Your Ref: LU/244/13/

Our Ref: PE/ARU/13/18/A/

Date: 18<sup>th</sup> September 2013

**Re: Land Parcel 1B, Courtwick Lane, Land South of Railway, Littlehampton.**

Type T324A
Elevations - Style 4 - Timber

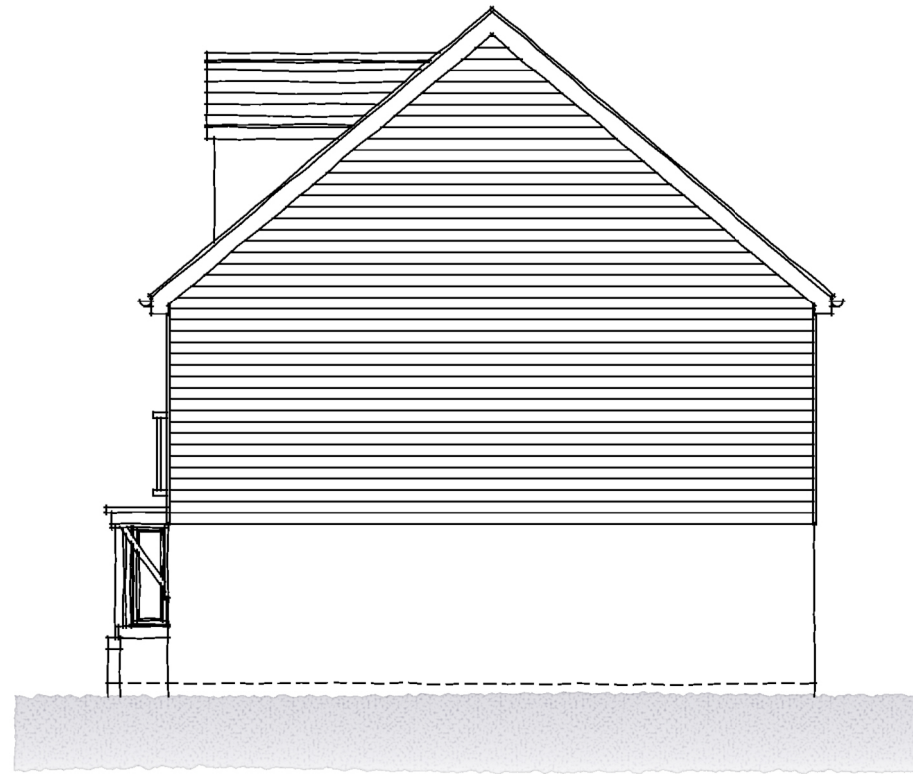
It is important to avoid the creation of windowless elevations and blank walls adjacent to space to which the public have access. These can have the effect of attracting graffiti and inappropriate loitering. An addition of a first floor window or a buffer zone can assist in reducing these concerns. Buffer zones can take the form of railings or defensible planting or a combination of both, i.e. the railing to indicate the private space and the planting to prevent direct access, this is also very effective on vulnerable windows.
